Your Ref: 23/04064/FUL
Our Ref: A000170

12th January 2024

Site Of Former 27 Skew Hill Sheffield - Demolition of existing buildings , erection of a dwellinghouse with assoicated parking and landscaping works

Drawing No: 23-018-008  
Drawing Title: Proposed Levels & Drainage  
Scale @ A1: As Noted

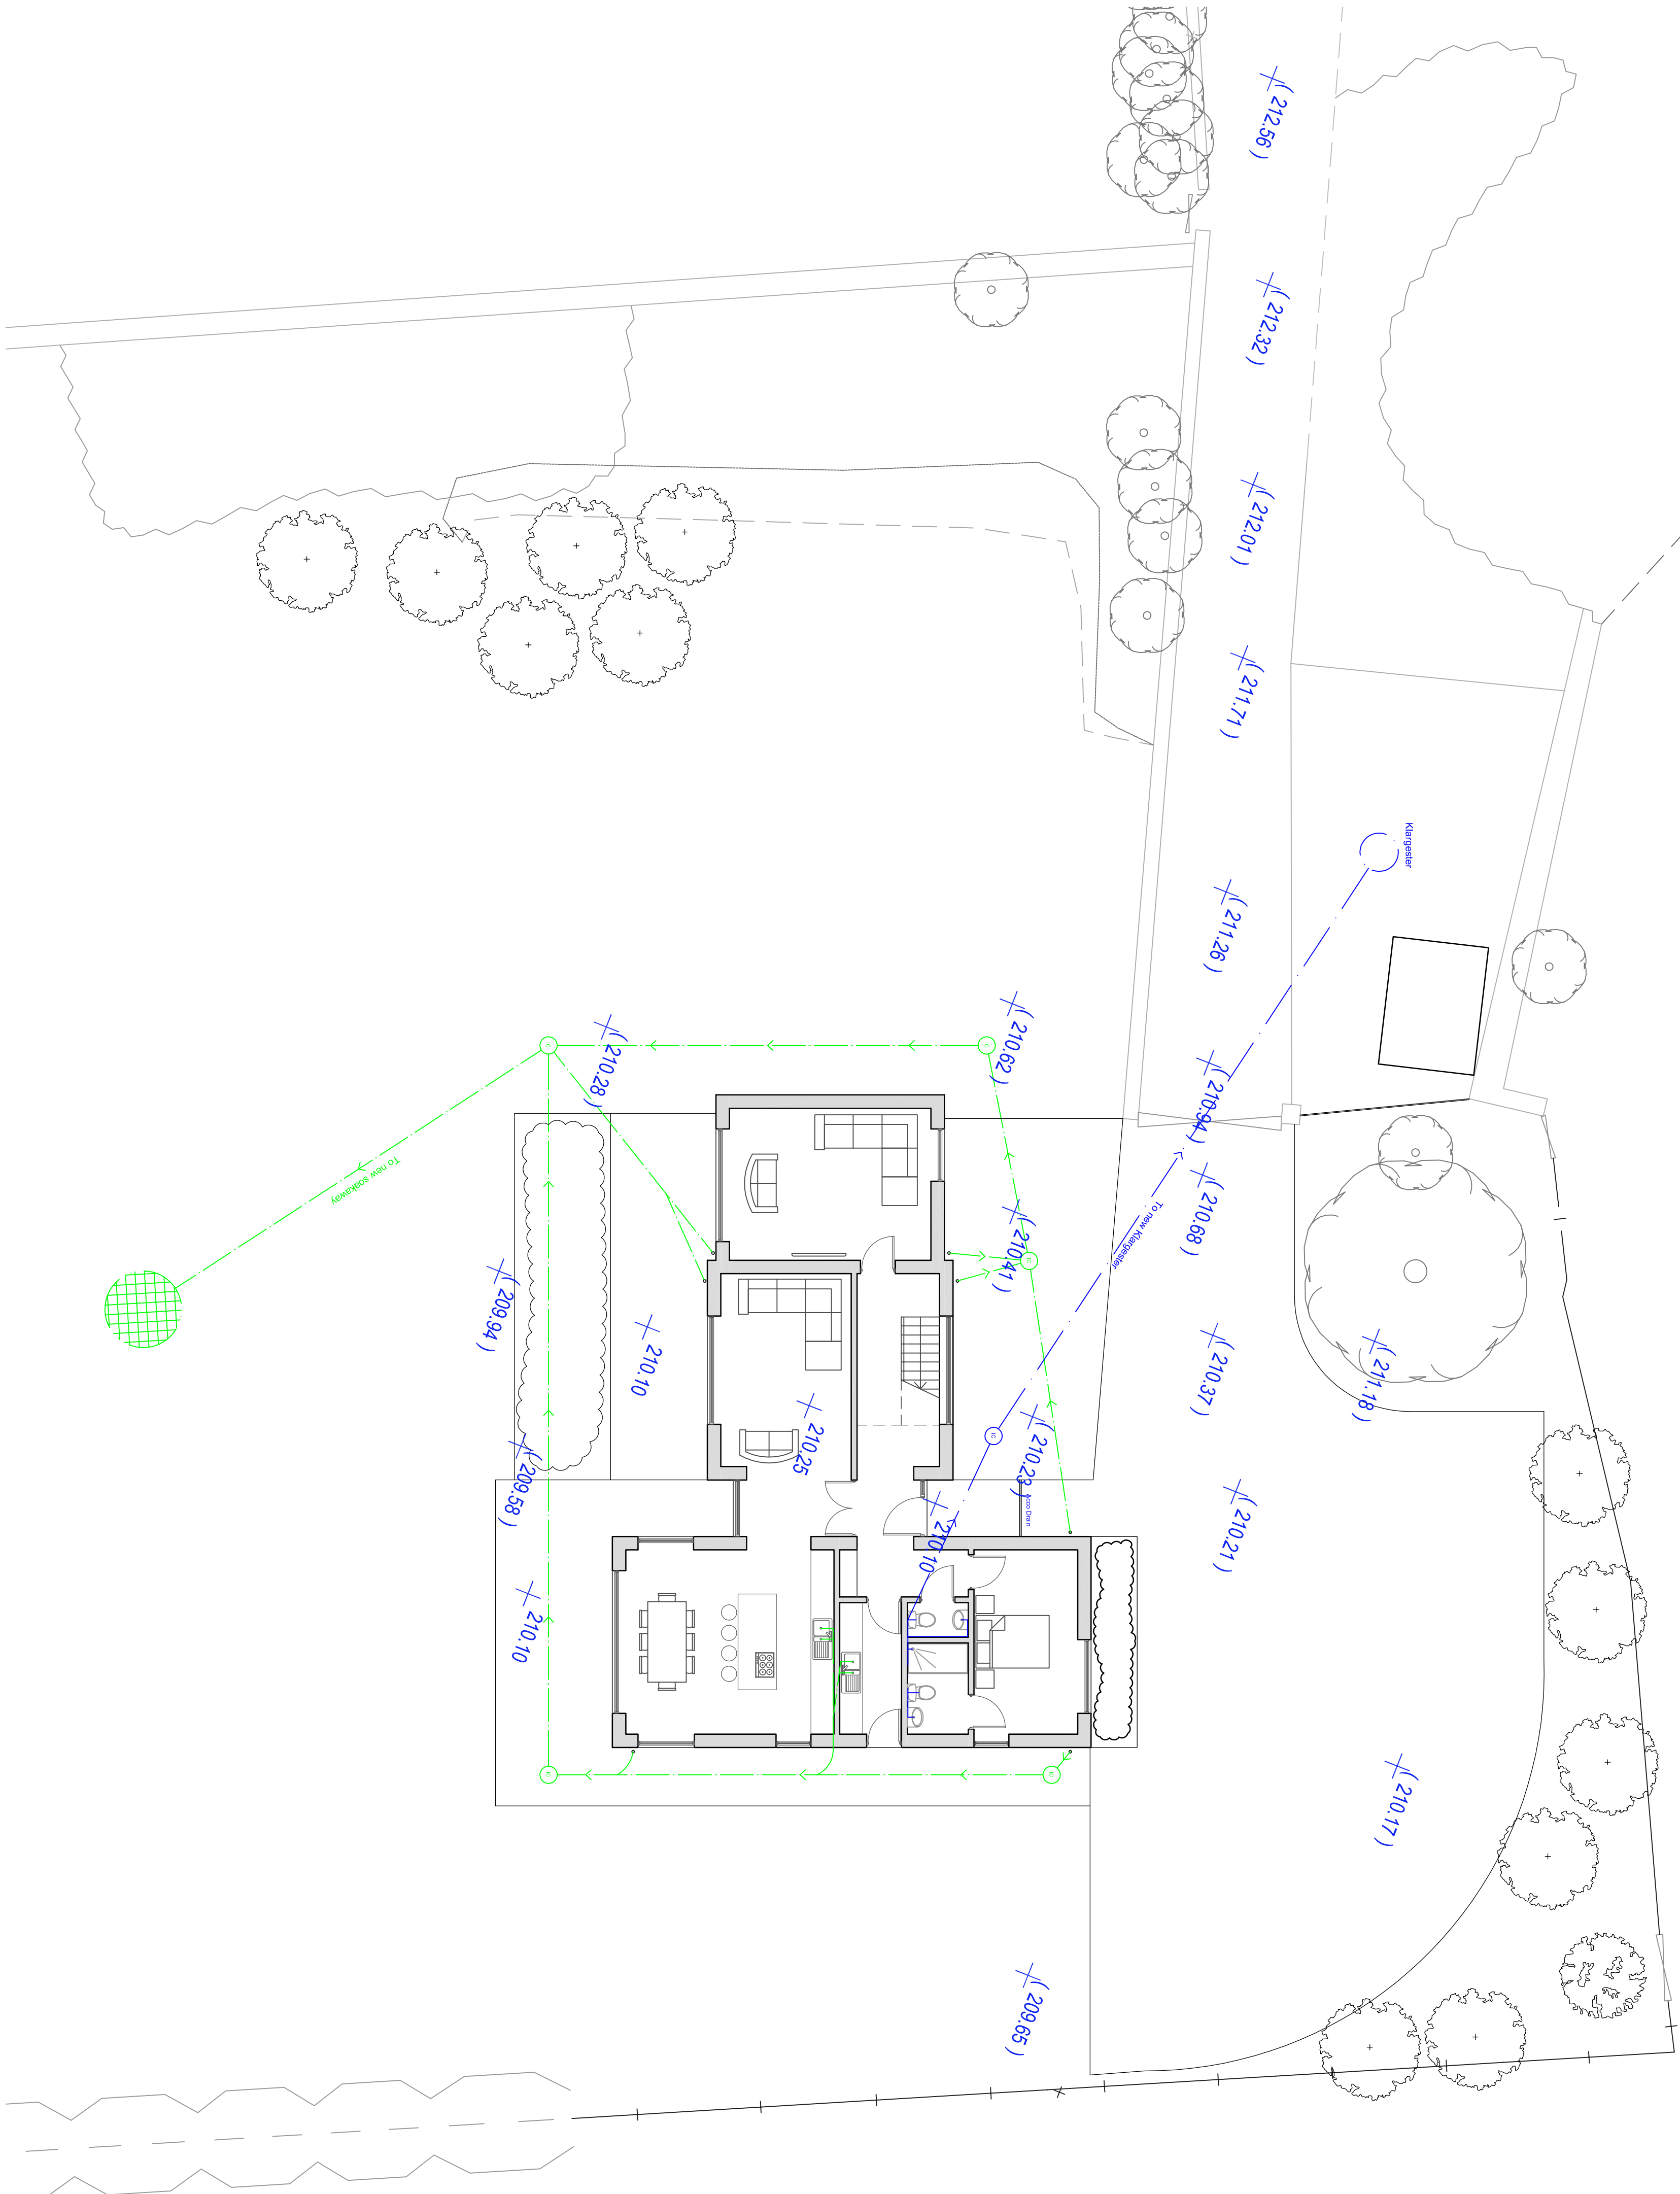
This proposal is in an area recorded as not served by the public sewerage network. In this instance, the application should be referred to the Environment Agency and the Local Authority's Environmental Health Section for comment on private treatment facilities.

The Proposed Levels and Drainage drawing that has been submitted, shows the position of a klargester (private) treatment system and the position of a new soakaway.
